Comments for Planning Application 24/00814/FUL

Application Number: 24/00814/FUL

Address: Timber Cottage Lumley Road Southbourne Emsworth West Sussex PO10 8AF

Proposal: Replacement dwelling.

**Proposed Lumley Road Elevation**  
1:100

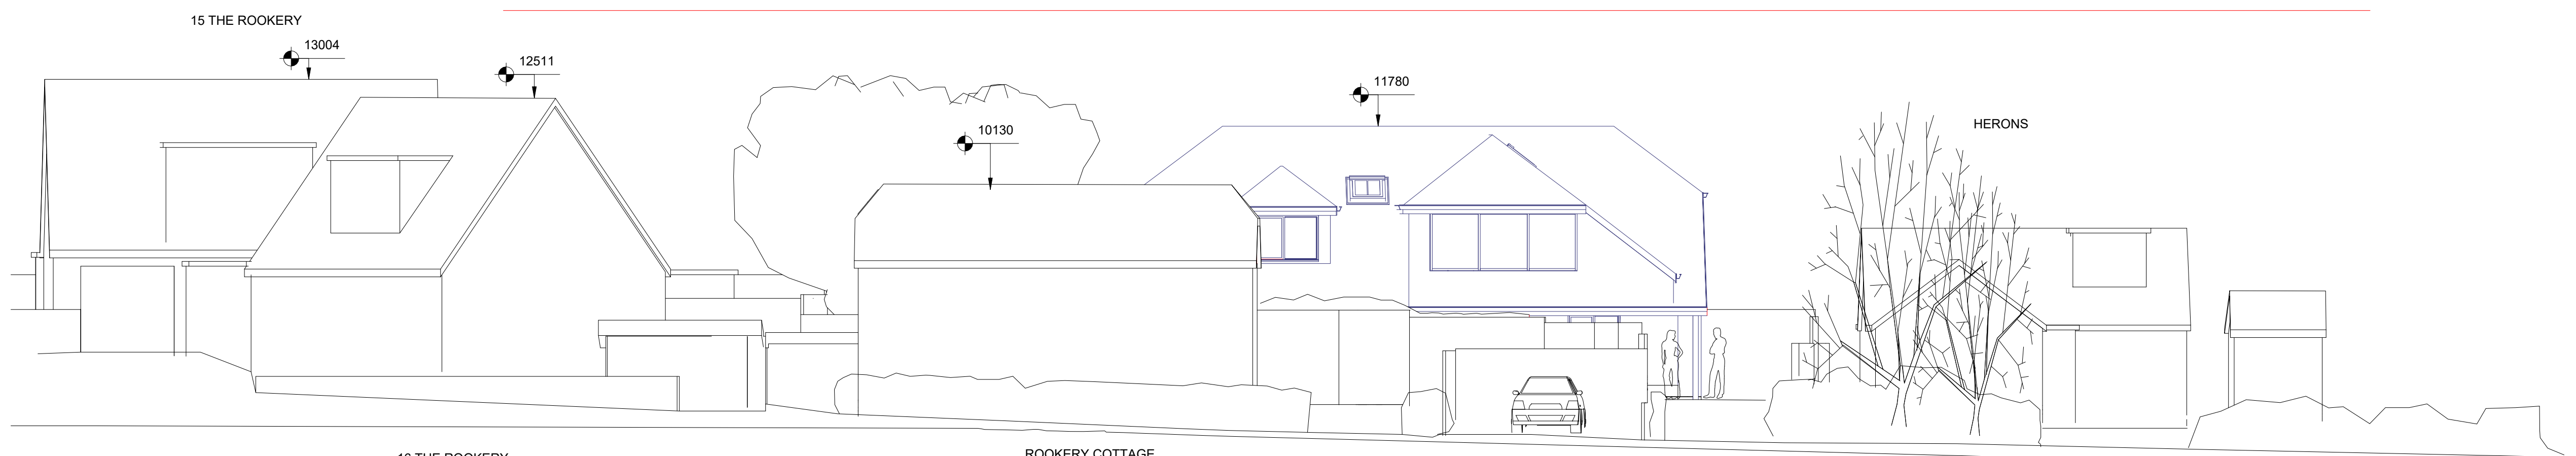
The Design and Access statement claims to address the reasons why the previous application was unsuccessful. It states that the previous design, as viewed from Lumley Road, appeared as a "2-storey dwelling". But in the new plan it still does. Stating that the proposed building is a "1.5 story bungalow" (and later even calling it a "Chalet bungalow") seems a somewhat misleading description of a 2-storey house. It would be over twice the height of the actual bungalow it plans to replace.

**Equinox 8am**

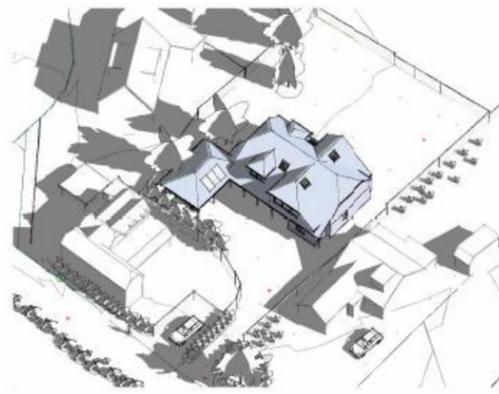
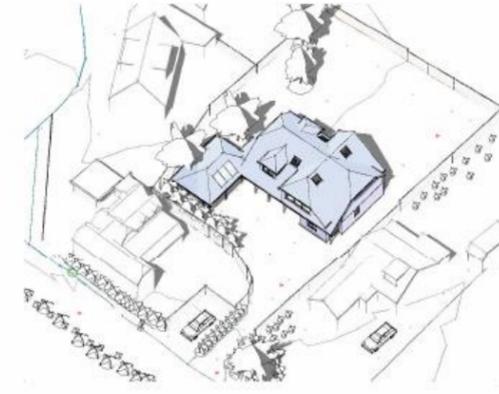
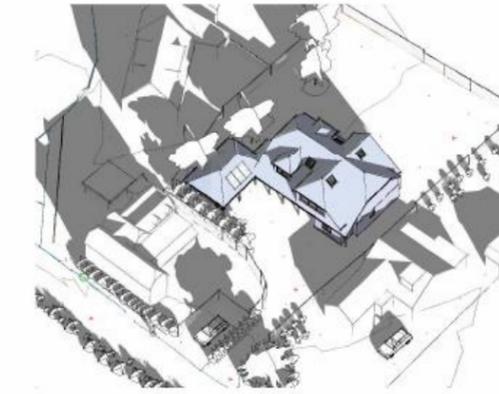
The statement includes diagrams that purport to illustrate that "the proposed building by virtue of its heights, form and position in relation to the neighbours will have little effect on the sunlight / shadows on adjoining owners' land." It goes on to state: "We have significantly reduced the bulk and mass of the building and carried out sunlight studies (p 14) to prove there will be minimal impact on light from a replacement dwelling in this location." Sunlight studies? Minimal impact? We have photos, taken on a sunny morning from the living rooms and kitchen of our neighbours in The Rookery that graphically show how morning sunlight that is currently enjoyed by them will be completely obscured by the proposed building.
